Rezoning Petition Review

Date of Review: April 9, 2008 (**Revised May 23, 2008**)

Rezoning Petition #: 08-83

Location of Property: Approximately 1.34 acres located on the northeast corner of The Plaza and Barrington Drive

EXISTING SITE PLAN

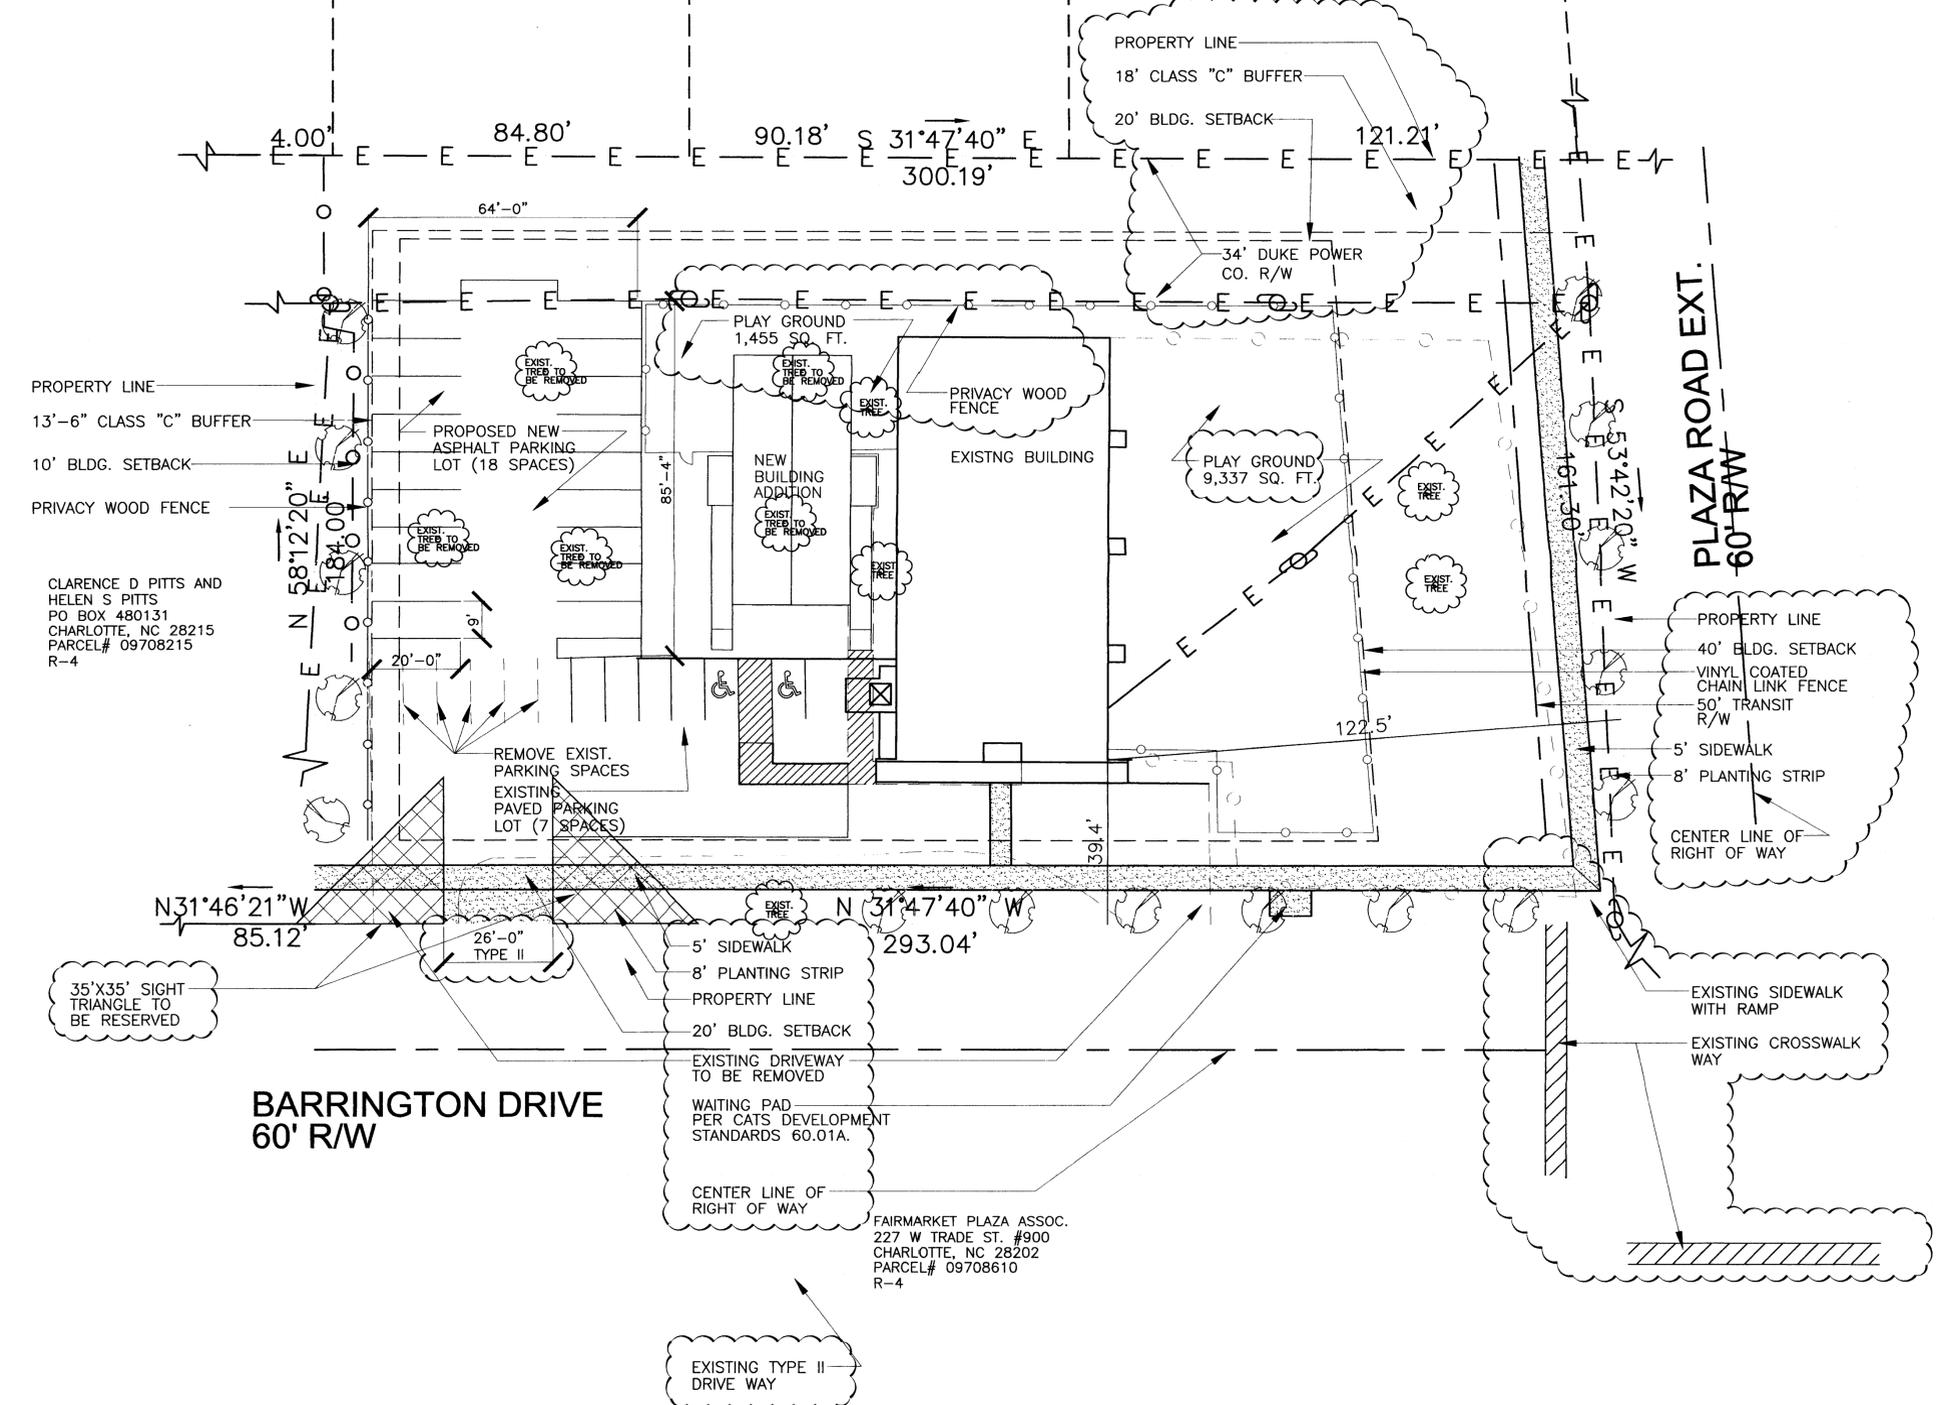
Recommendations Concerning Storm Water: **Remove General Note #1-Storm Water, General Note #13- Storm Water Detention and Include the following notes on the petition.**

The petitioner shall comply with the Charlotte City Council approved and adopted Post Construction Controls Ordinance.

The following agencies must be contacted prior to construction regarding wetland and water quality permits:

Section 401 Permit NCDEHNR – Raleigh Office (919) 733-1786
Section 404 Permit US Army Corps of Engineers (704) 271-4854
